Our Ref: R/284/17/PL

**Town & Country Planning Act 1990 (as amended)
Town and Country Planning (Development Management Procedure) (England) Order 2015
Application for Planning Permission**

Development Convert existing garage/studio space into a 2 bed. short term holiday let. Removal of small section of existing flint wall to the section adjoining the garage (approx 3m) to create garden access & off road parking.

Location 62 Ash Lane Rustington

Block Plan shows area bounded by: 505454.55, 102488.64 505544.55, 102578.64 (at a scale of 1:500), OSGridRef: TQ 549 253. The representation of a road, track or path is no evidence of a right of way. The representation of features as lines is no evidence of a property boundary.

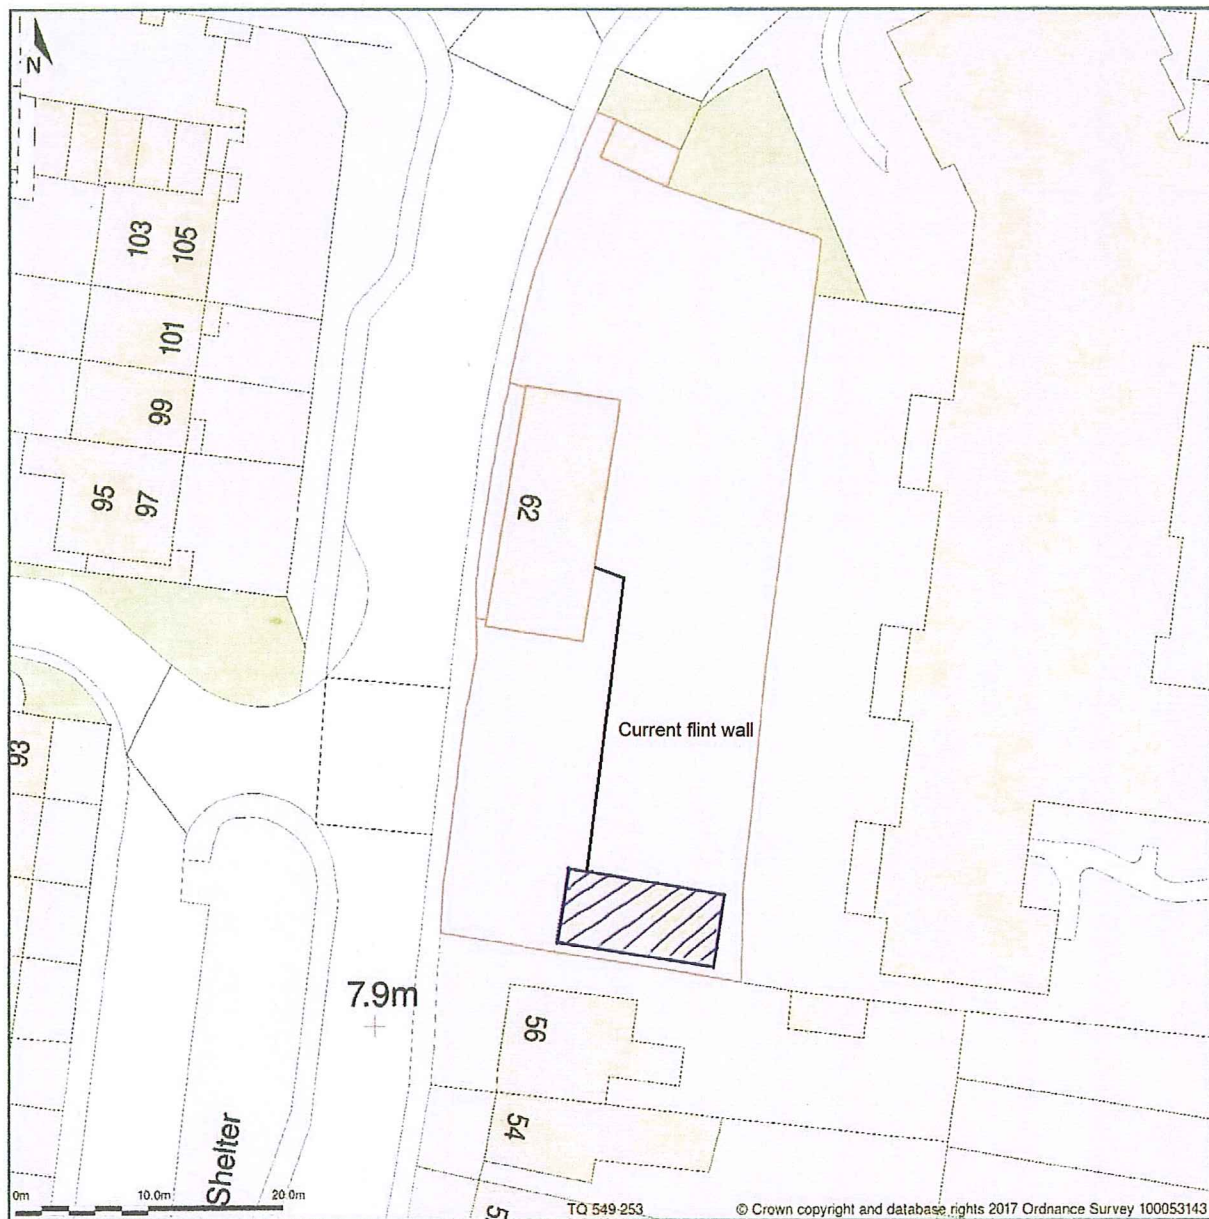
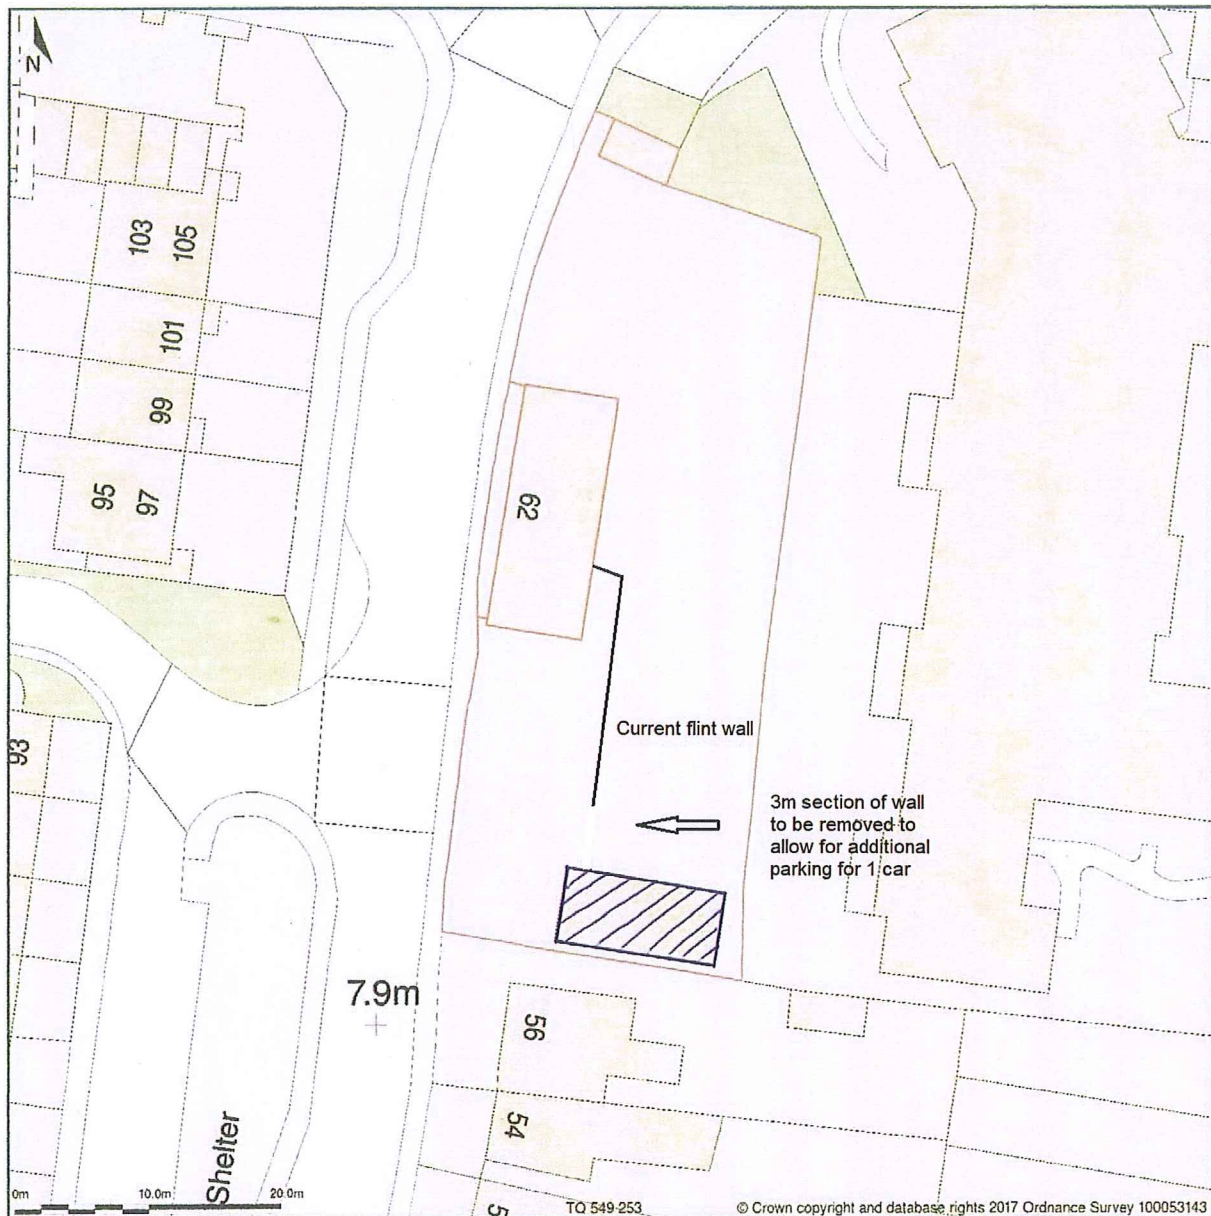
Block Plan

Please submit 1 electronic or 3 paper copies of an amended block/site plan at a scale of 1:500 or 1:200 to show the position of the works clearly highlighted. Further details of what must be included on the plan can be found in the National Validation Requirements.
